RE: [#2022091] – Avanzando Development (Rio Bravo Blvd. / Loris Dr.)

This letter is for the purpose of addressing comments from the City of Albuquerque (Matt Grush), Bernalillo County (Julie Luna), and the New Mexico Department of Transportation (Margaret Haynes). Following are my responses:

## Avanzando Conceptual Site Plan

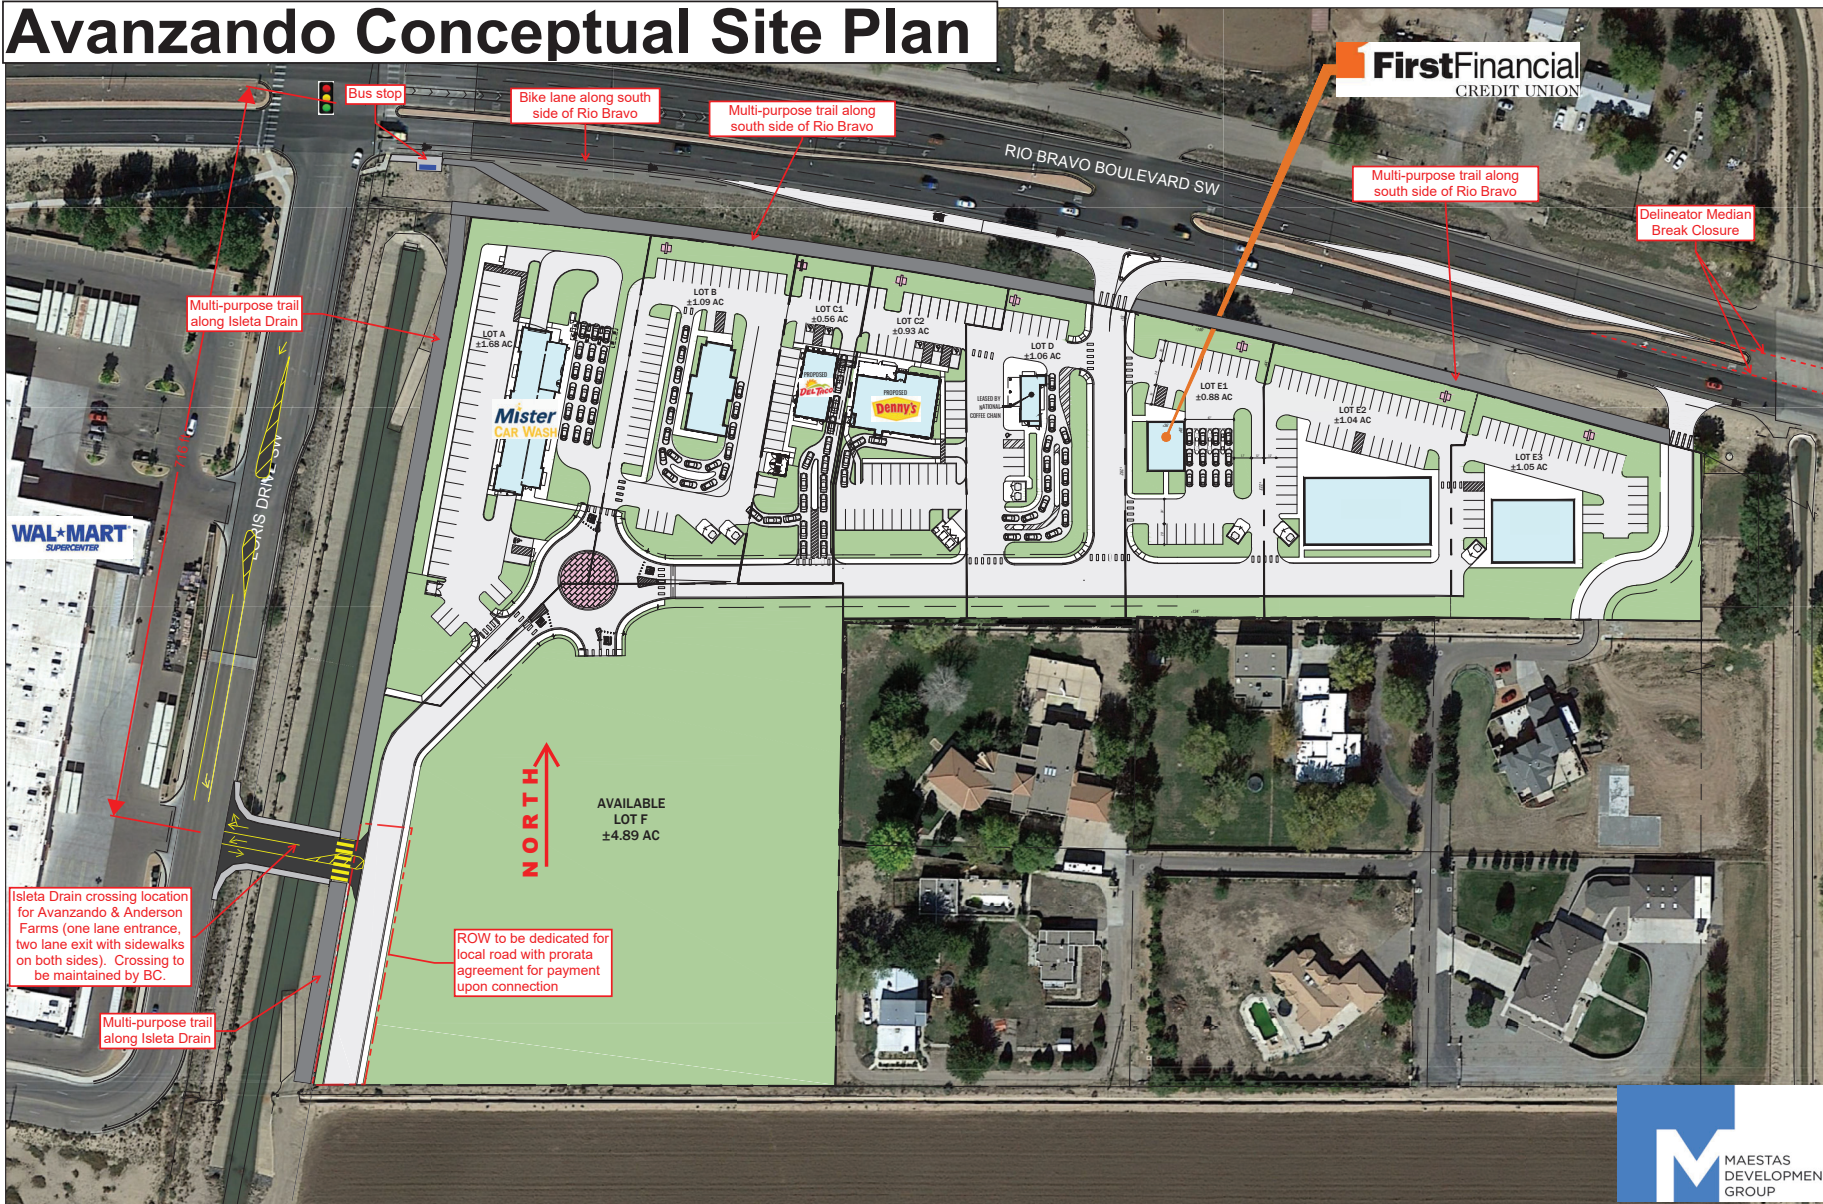
Page 2- Missing section for "Description of proposed development". Bring site plan to report.

Complied.
